City of Portland, Maine - Building or Use Permit Application

Permit No: 02-0956	Issue Date: SEP - 5 2003	CBL: C014001
-----------------------	------------------------------------	-----------------

Location of Construction: 30 West Lynne Ave	Owner Name: Beal	Owner Address: 30 West Lynne Ave	Phone: 2897
Business Name: n/a	Contractor Name: n/a Greg Plimpton	Contractor Address: n/a n/a 772-3600	Phone:
Lessee/Buyer's Name: n/a	Phone: n/a	Permit Type: Additions - Dwellings	Zone: R-3

Past Use: Single Family	Proposed Use: Single Family / Add 550 sq. ft. Deck on rear of house.	Permit Fee: \$135.00	Cost of Work: \$16,000.00	CEO District: 2
-----------------------------------	--	--------------------------------	-------------------------------------	---------------------------

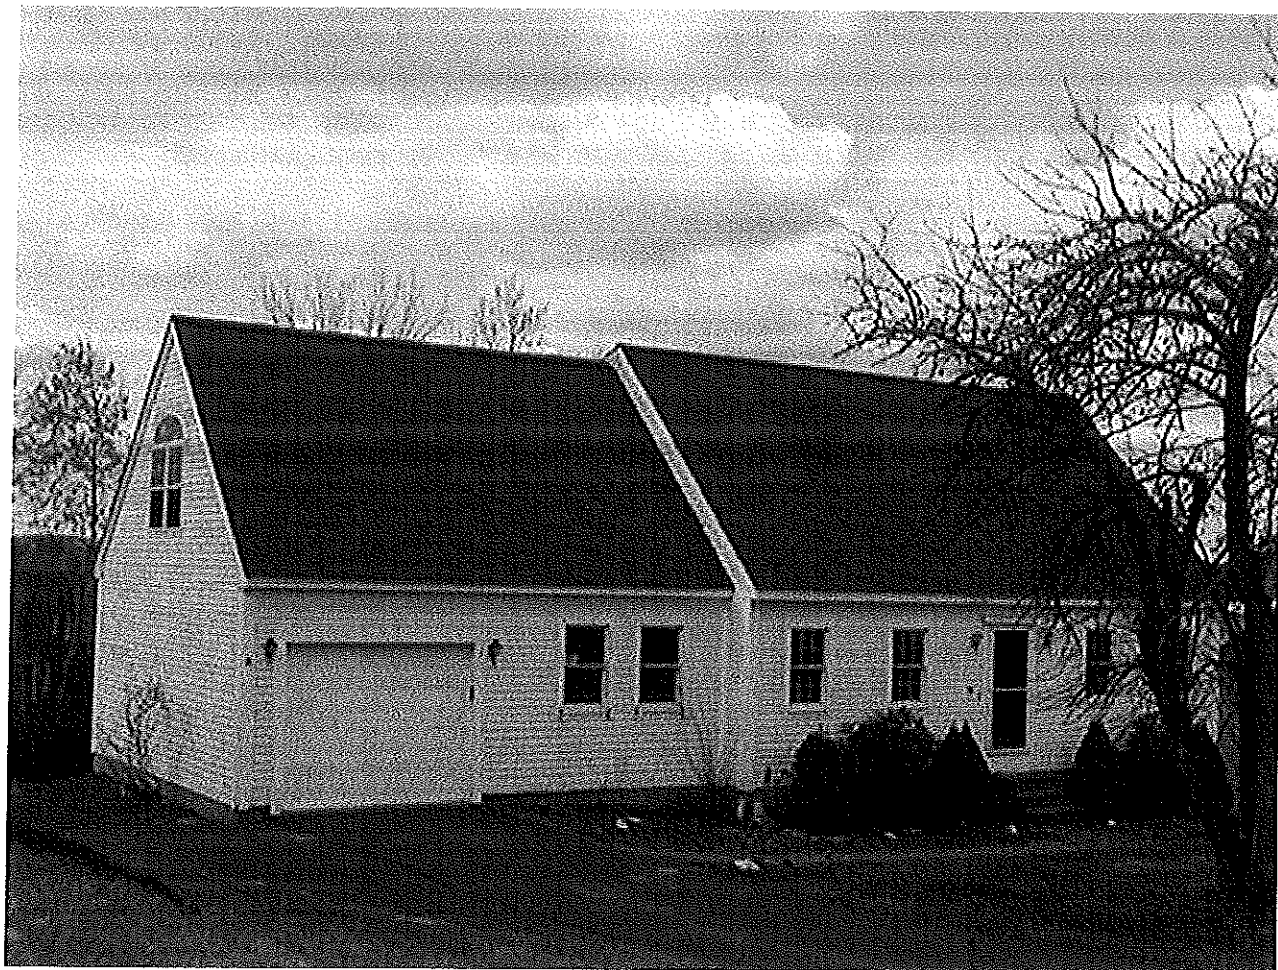
Address: 30 West Lynne Ave
8/29/02 R-2 zone - only showing 10' side setback where 12' is required - I called Greg Plimpton as shown on the application and left a message - talked to contractor, he revised plans and will be 12' from the side property line.

It is understood thru a conversation with the contractor that there shall be a 12' side yard setback on the left side of this deck which complies with the R-2 zoning requirements. All setbacks are measured to property lines. The Code Enforcement Officer shall be checking the setbacks PRIOR to the placing of any concrete.

FRAMING PLAN

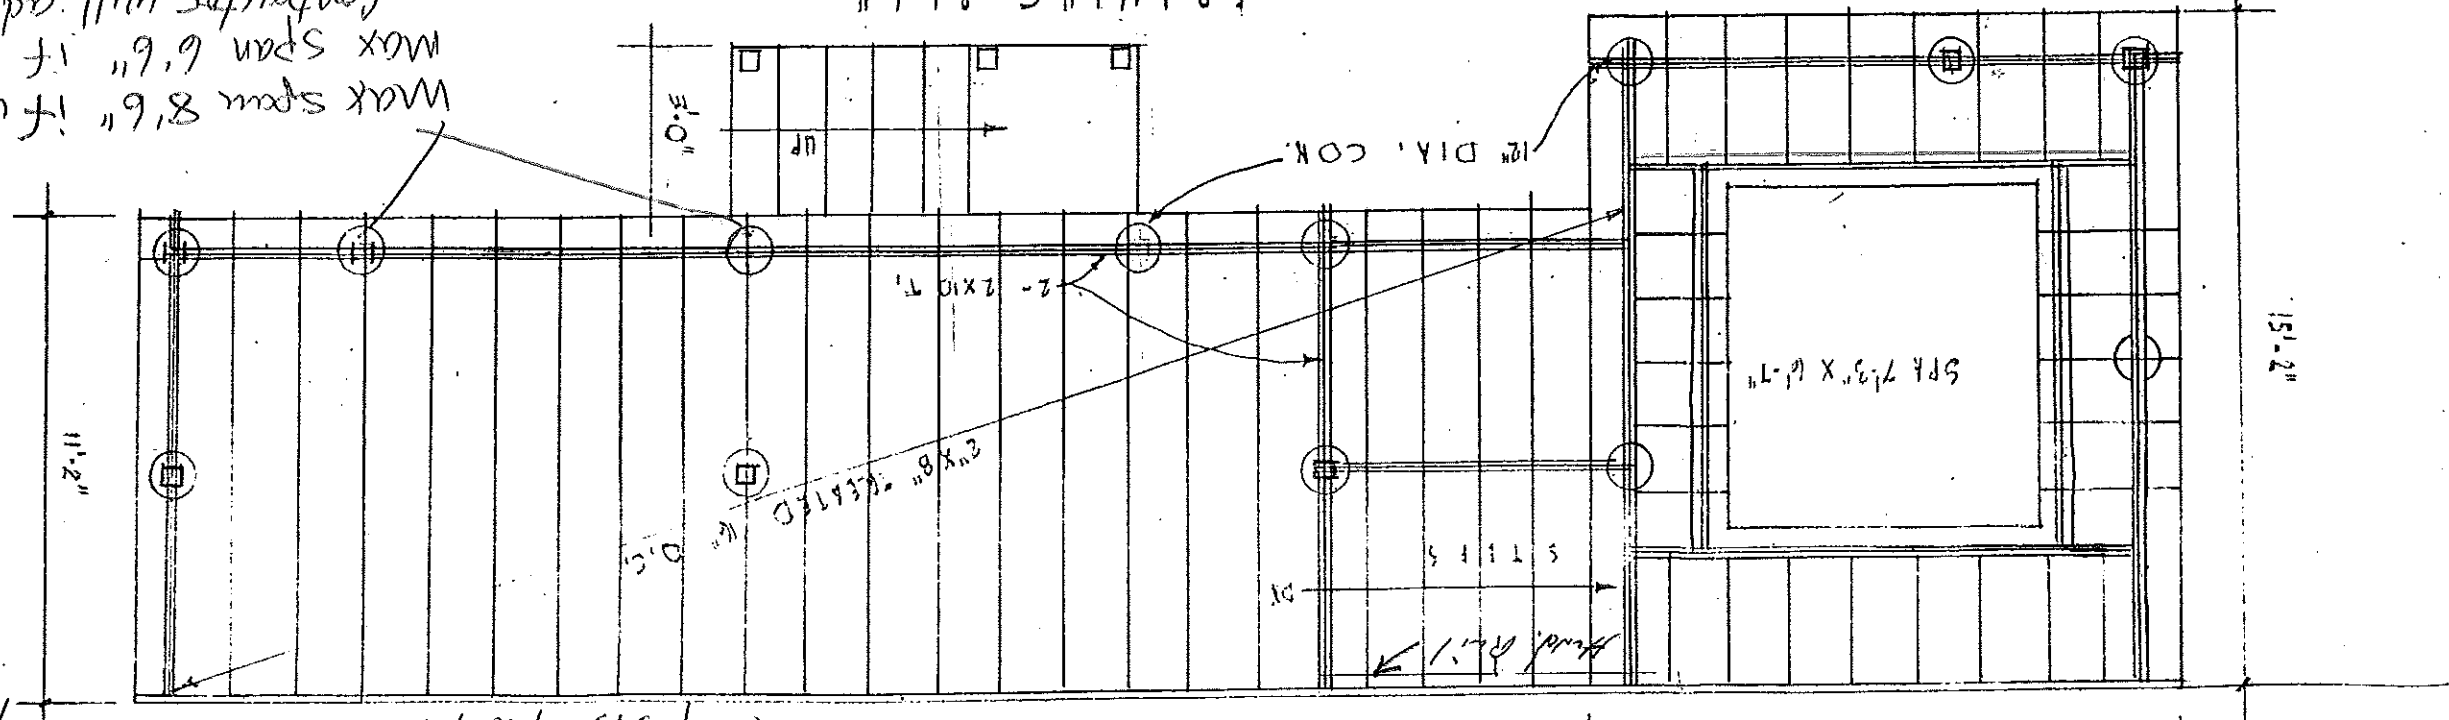
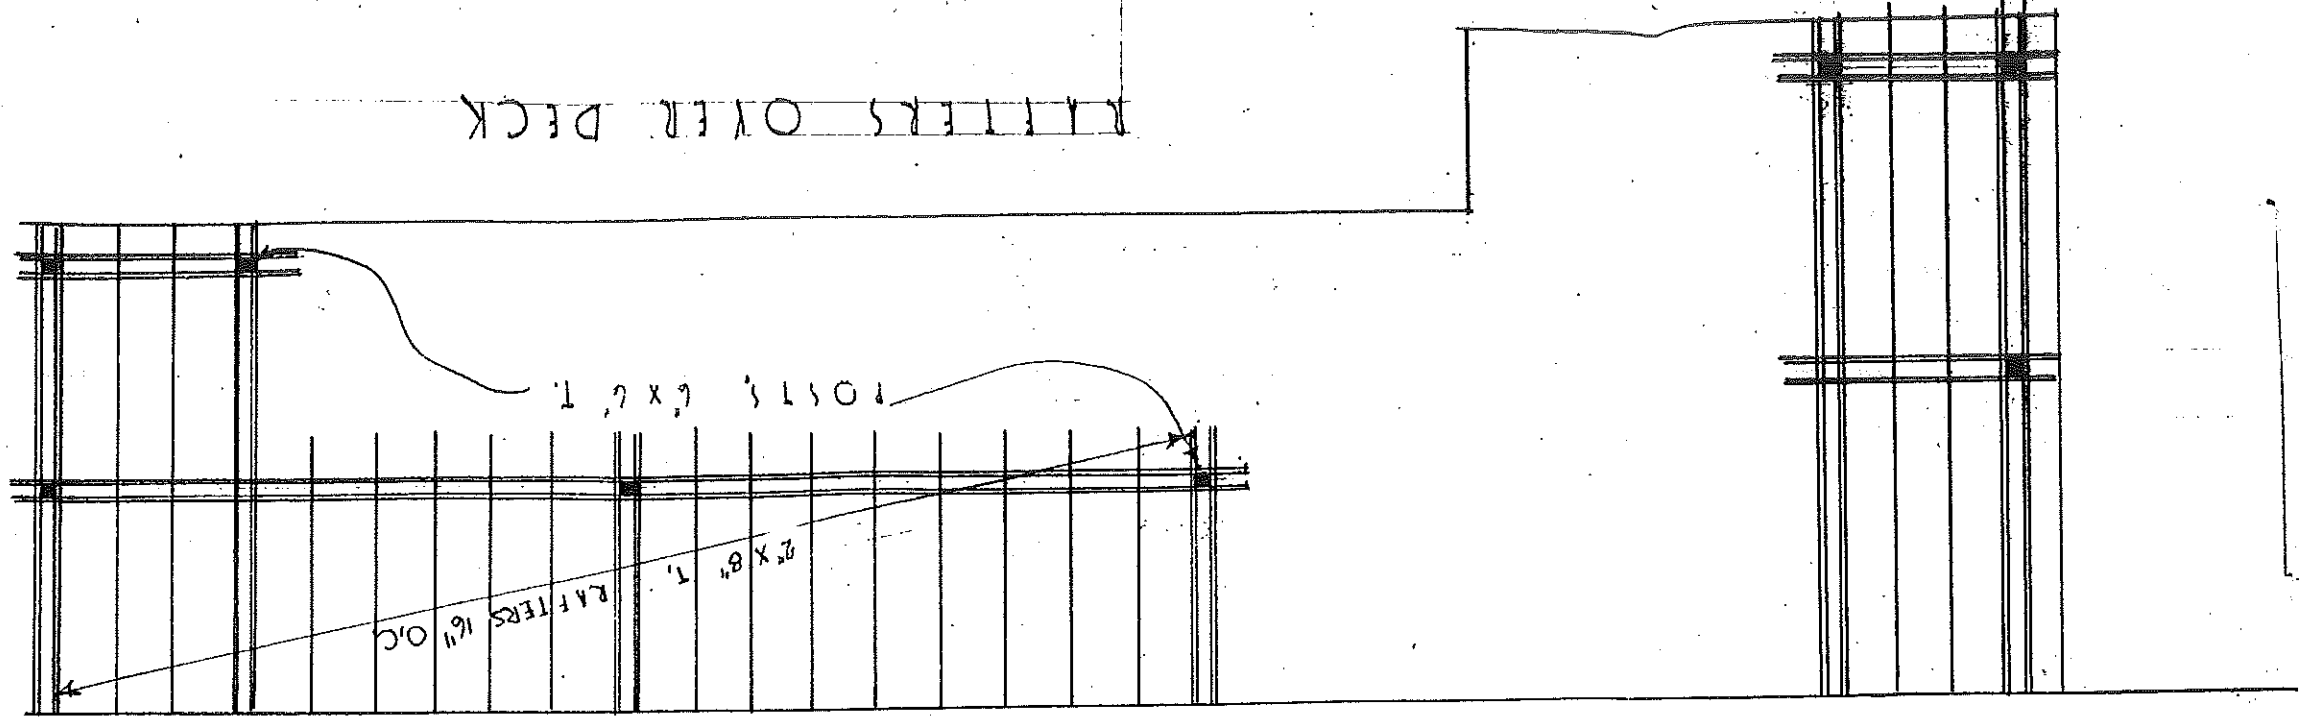
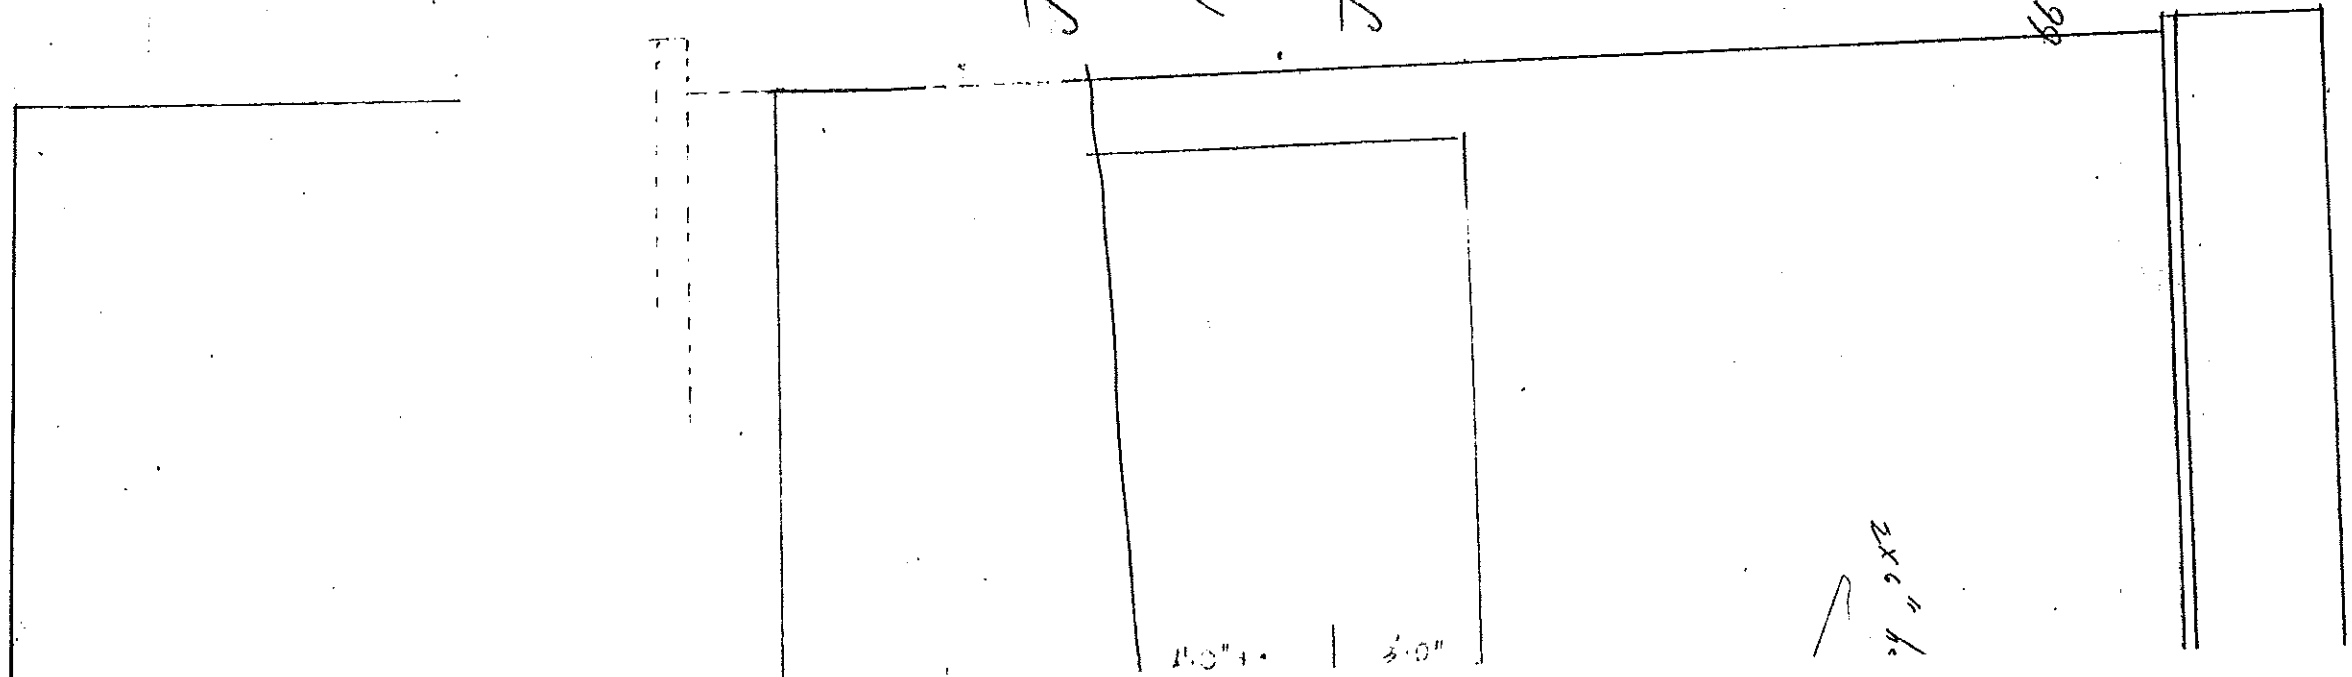
- 1 - All footings to be 48" depth or to ledge
- 2 - Rim ledger bracketts bolted thru foundation
- 3 - Joist hangers installed at all non-bearing points
- 4 - Headers and beams around spa cut out to be doubled
- 5 - Arbor rim to be bolted to wall studs
- 6 - Posts or girders to be fastened to sona footings
- 7 - Guardrail system to meet BOCA '99 Sec. 1021

Contractor will adjust footing spacing on site for girder support:
 Max span if using 2-2X10 = 8' 6"
 Max span if using 2-2X8 = 6' 6"
